Please ask for: Nicola Moore
Email: nicola.moore@arun.gov.uk
Telephone: Ext 37944
Our Ref: AB/19/22/HH
Your Ref:
Date: 28th February 2022

Application for Planning Permission for Works or Extension to a Dwelling

Development: Proposed side extension, loft conversion, changes to external finishes, together with internal alterations and all associated drainage works
Location: 39 Priory Road Arundel BN18 9ET

JOB NO.	DRAWING NO.	REVISION
21099	2.03	B

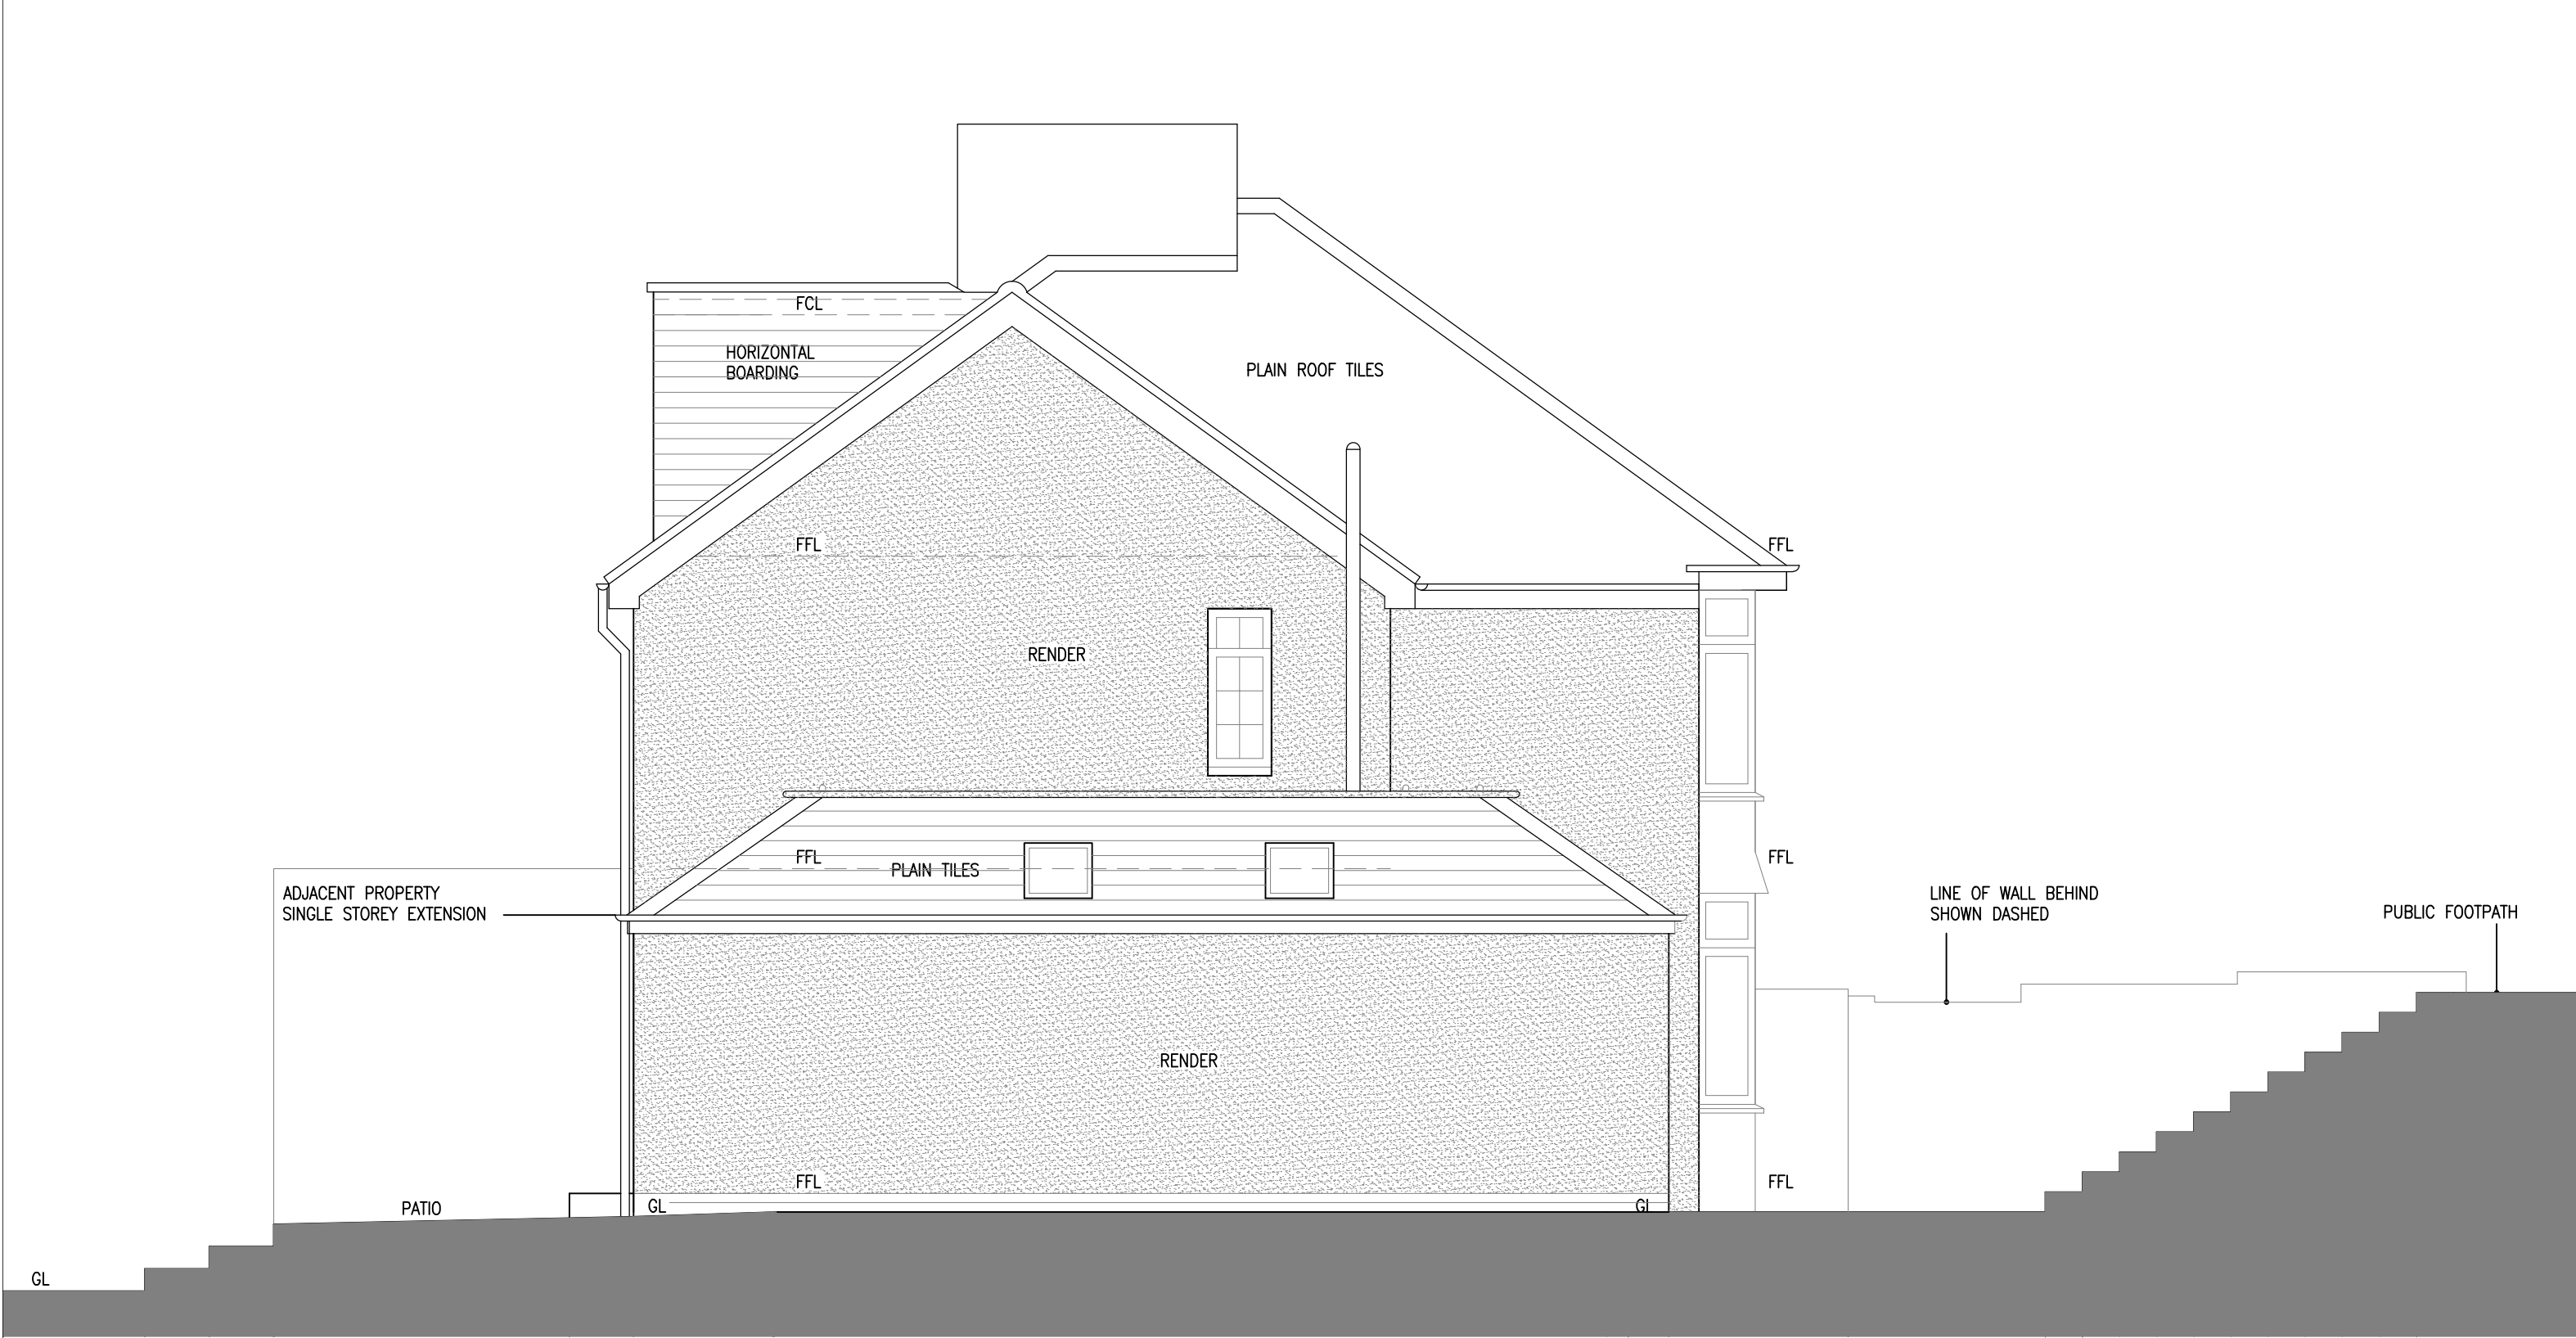
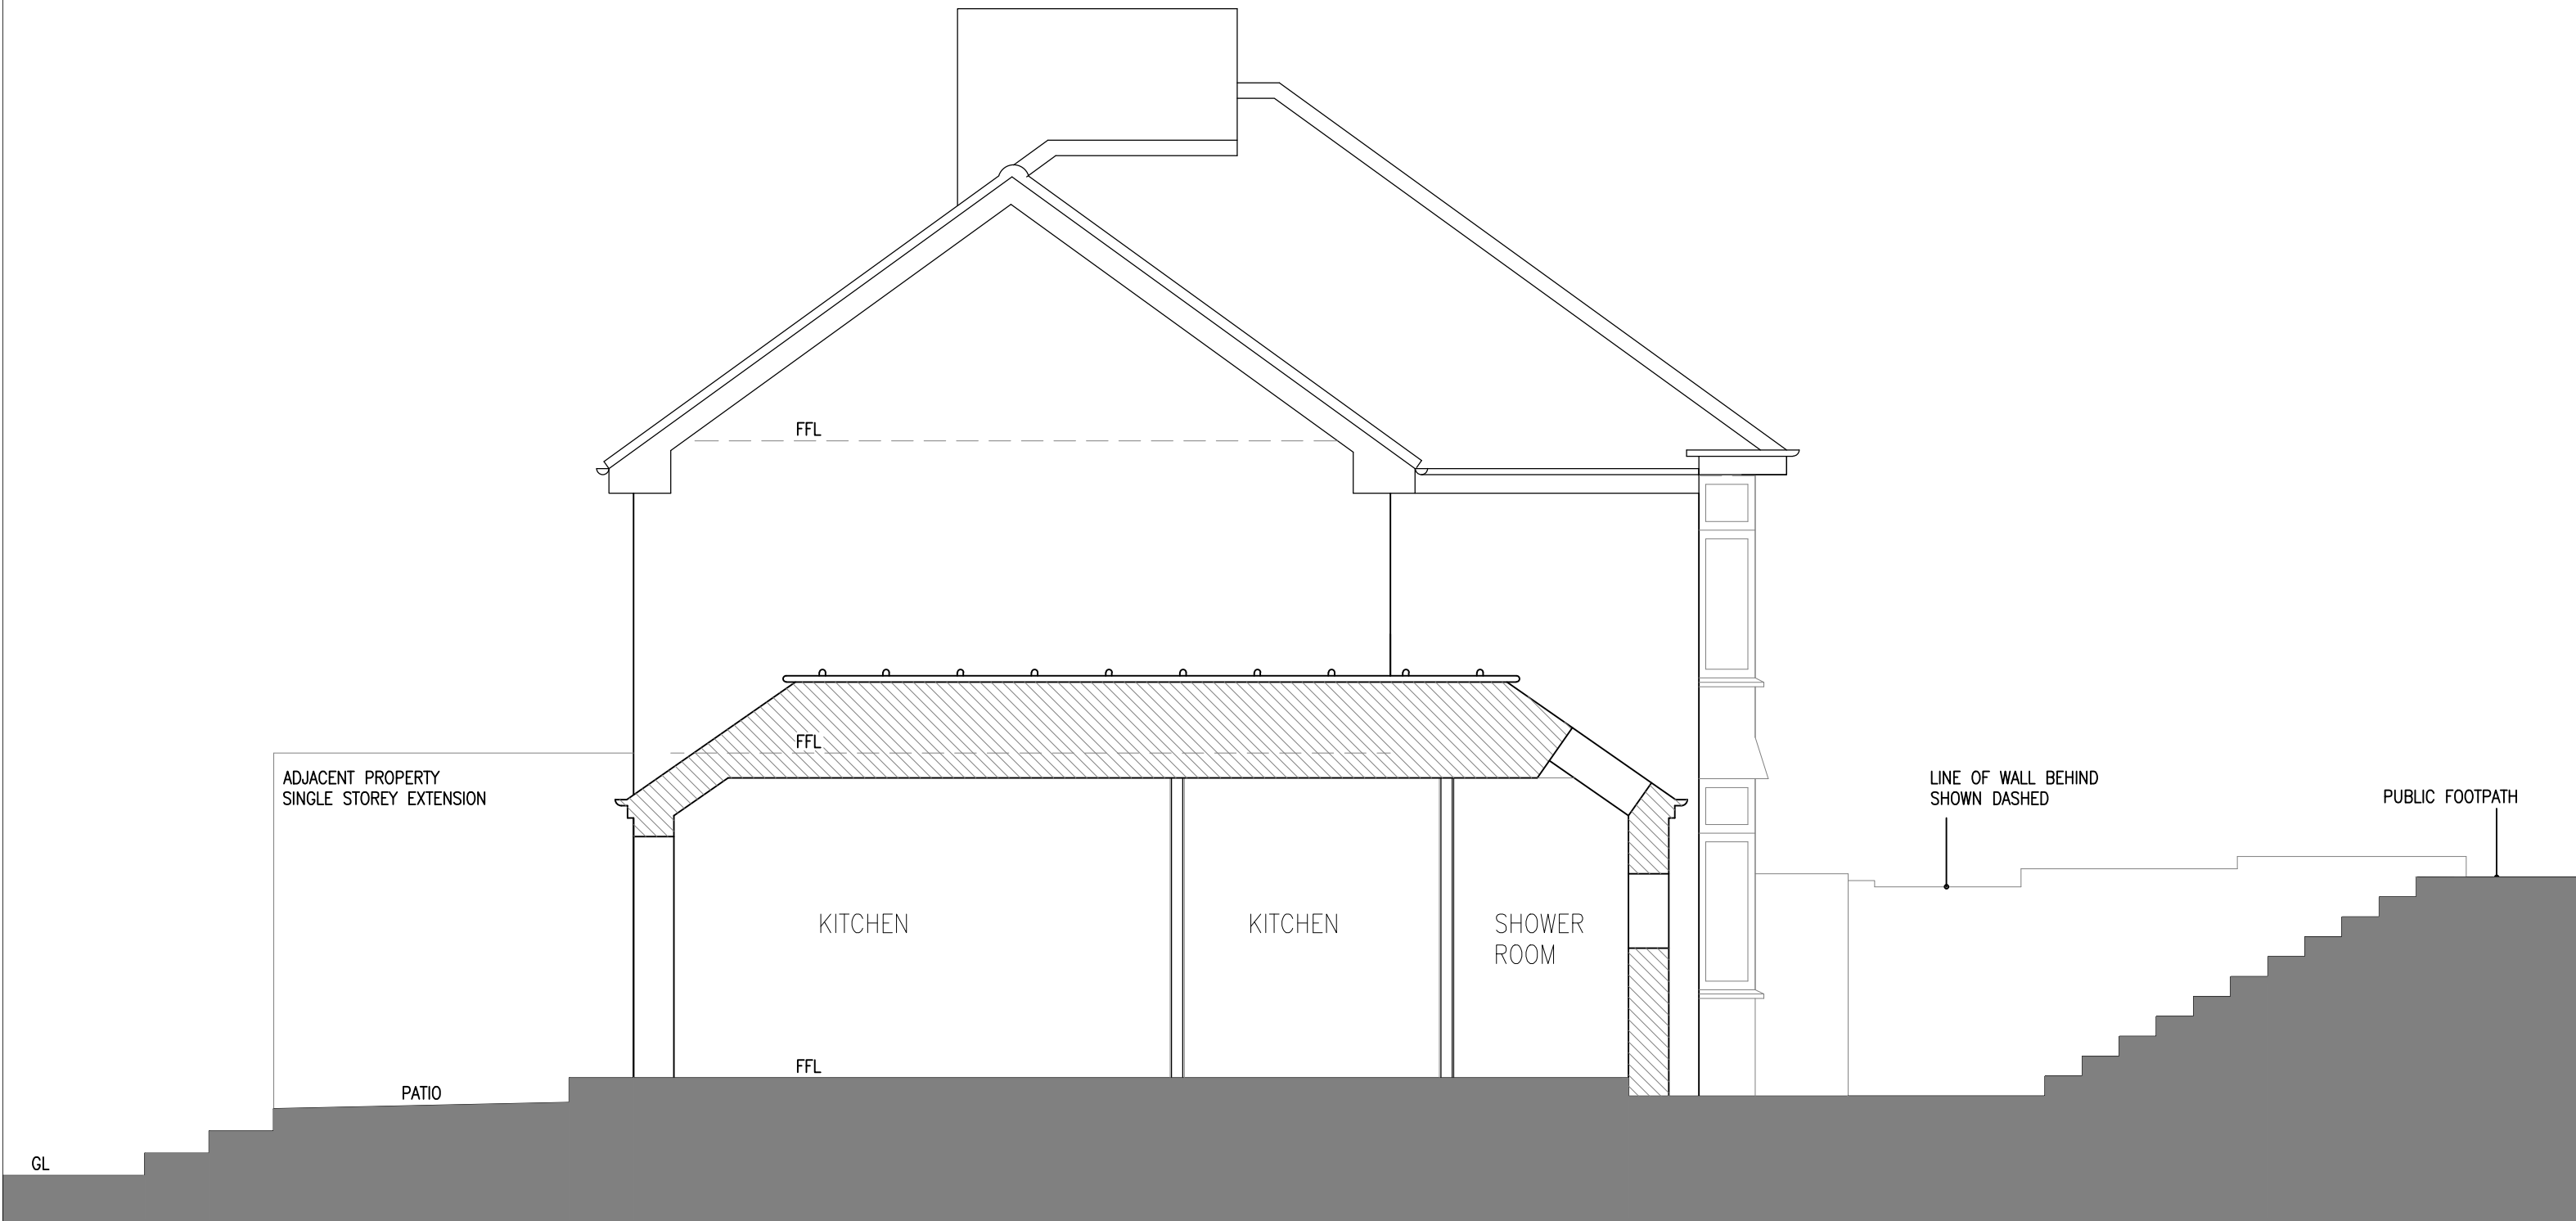
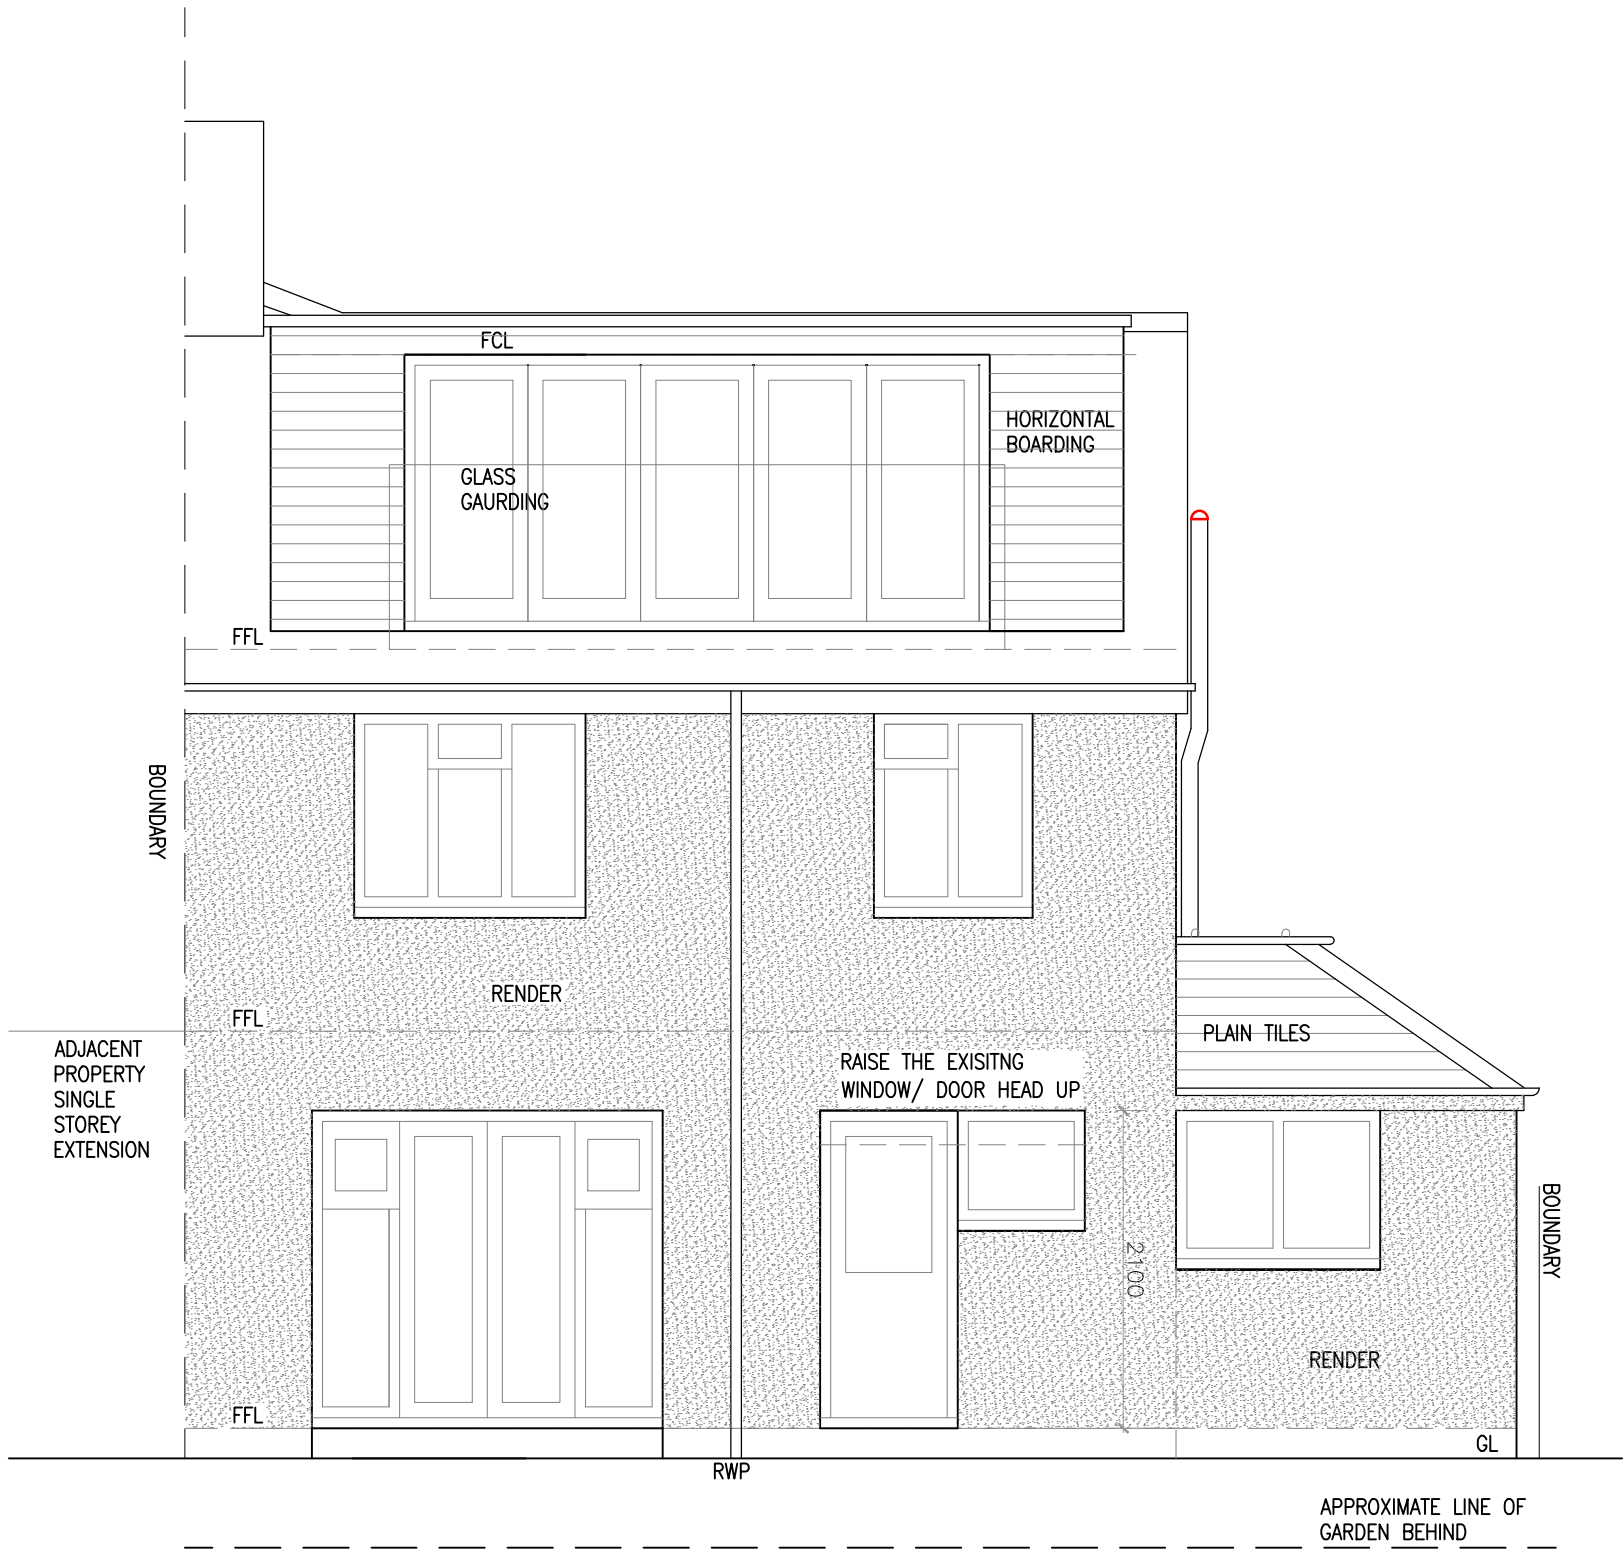
Dwg No 2.03 Rev A is titled Elevations and Section as Proposed, but the each elevation/section is titled existing. Please amend accordingly and re submit.
